**Re: Corner at the Alamedas Office/Warehouse, 8615 Alameda Park NE, Grading Plan**

re: Corner at Alameda Office / Warehouse, 8615 Alameda Park NE  
file: C16/D007

**Re: Corner at the Alamedas Office/Warehouse, 8615 Alameda Park NE, Grading Plan**

**Engineer's Stamp dated 8-13-07 (C16/D007)**

4 CONCRETE CHANNEL
3/4"=1'-0"

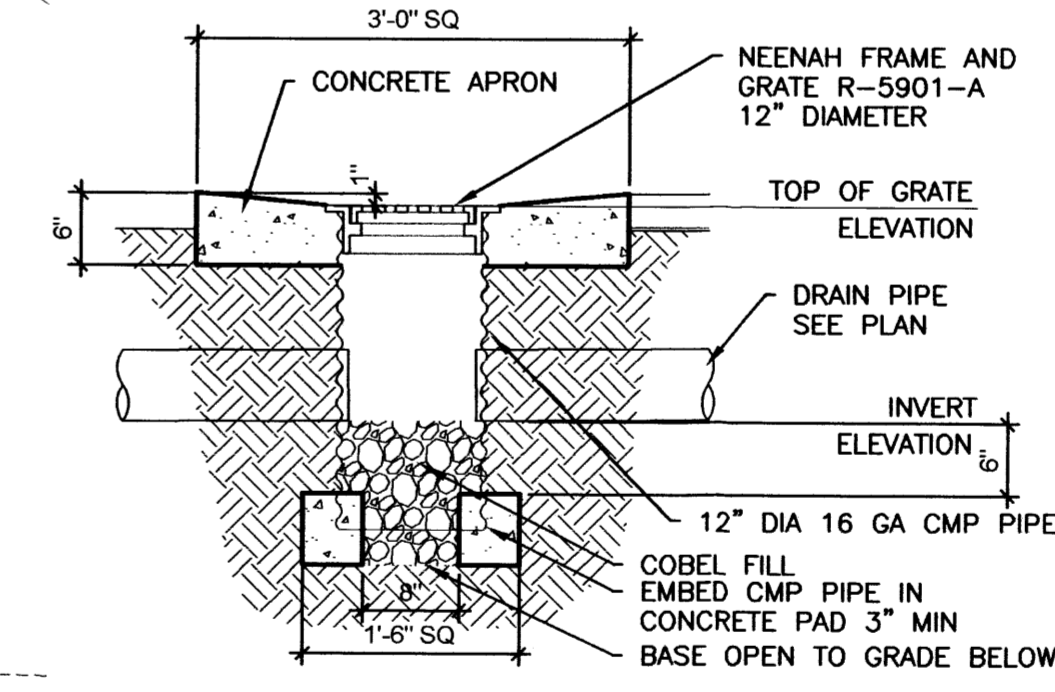
- There is a typo on an invert build note for the 1-foot wide channel just south of the building. The 34.0 INV should most likely be 35.0 INV.
- Specify a retaining wall on the south edge of the building.

1. An enlarged plan detail of the transition has been provided as requested.
2. The drain in the trash enclosure has been delete.
3. There is a trench drain along the south side of the building. The retaining wall of the stair functions as the headwall of the discharge pipe. A detail of the trench drain has been added to the drawing.
4. The side walk culvert has been extended to the face of curb as requested. The culvert width is 2'-0" and the flow line elevations of the culvert have been noted.
5. The elevation notation has been corrected.
6. The building is acting as the retaining wall along the loading dock on the south side of the building.

5 CATCH BASIN
3/4"=1'-0"

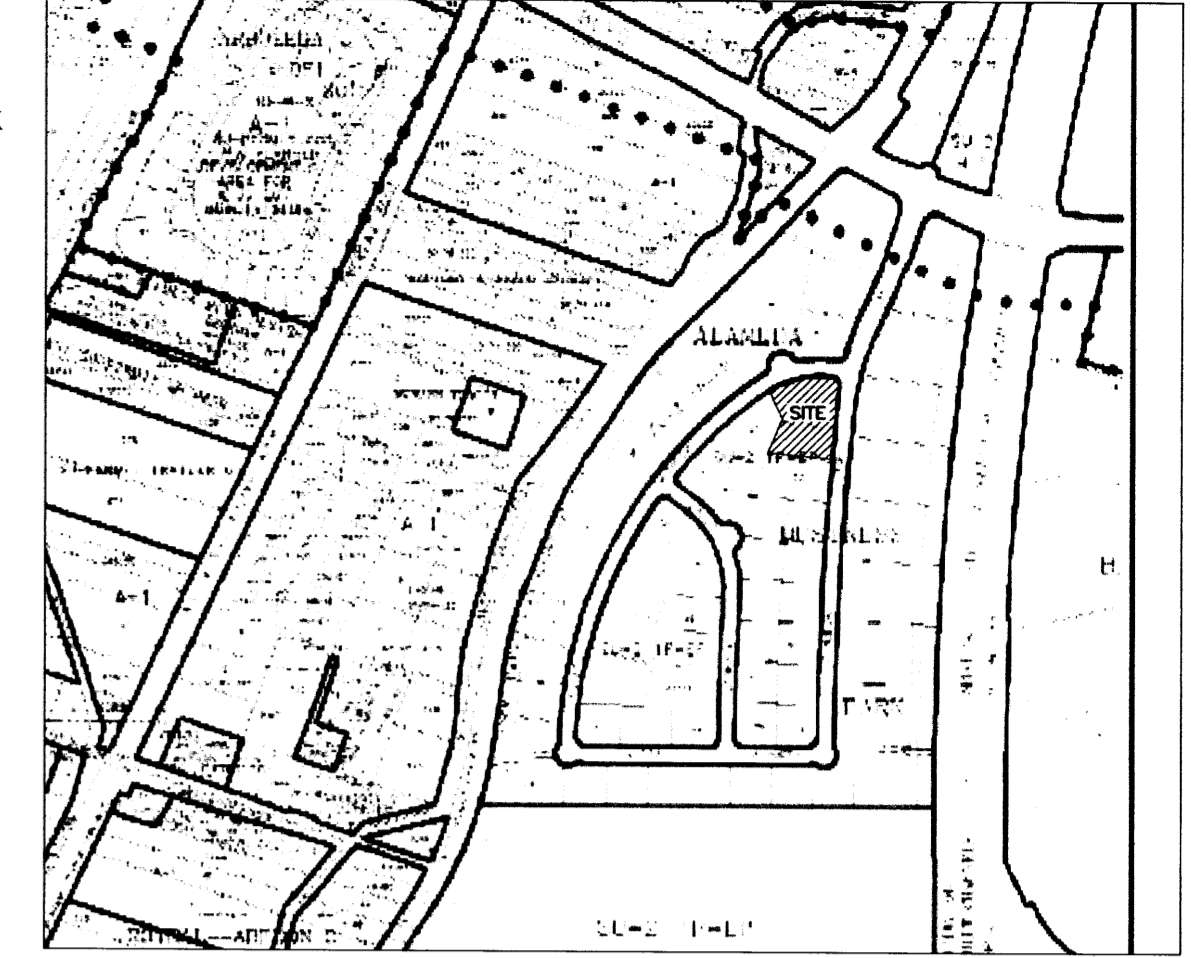
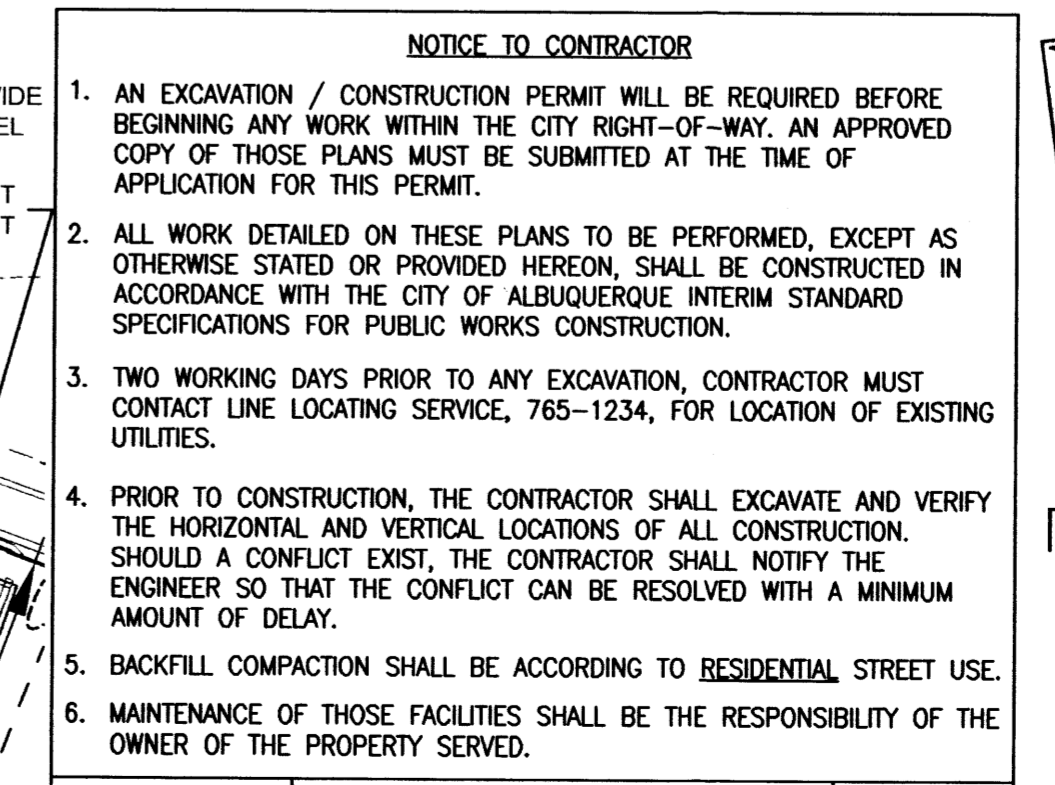
- It appears a catch basin is required just east of the west stairs on the south side of the building. Also, it appears there is a typo "TG" where an invert should be called out.

A1 SITE GRADING PLAN
1"=20'-0"

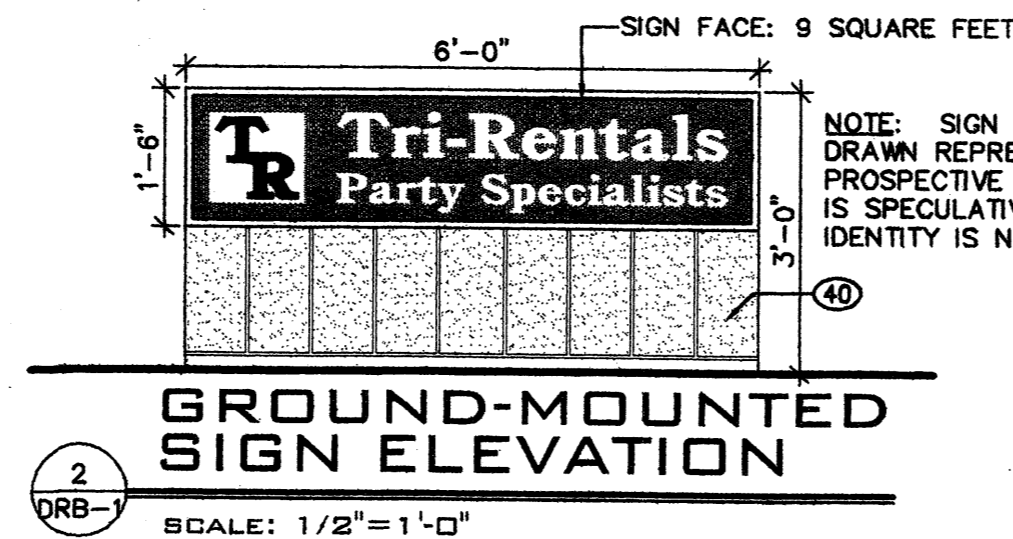
- Provide a detail of the area where the 2 ft wide channel meets the existing channel in the southwest corner of the site.
- Currently, only food preparation businesses require the trash enclosure to drain through a grease trap to the sanitary sewer. Trash enclosures at other business types should not drain to the sanitary sewer.

- Specify the width and the upstream invert of the sidewalk culvert east of the drive entrance on Paseo Alameda. In addition, sidewalk culverts extend to the face of curb. Please redraw to reflect this.
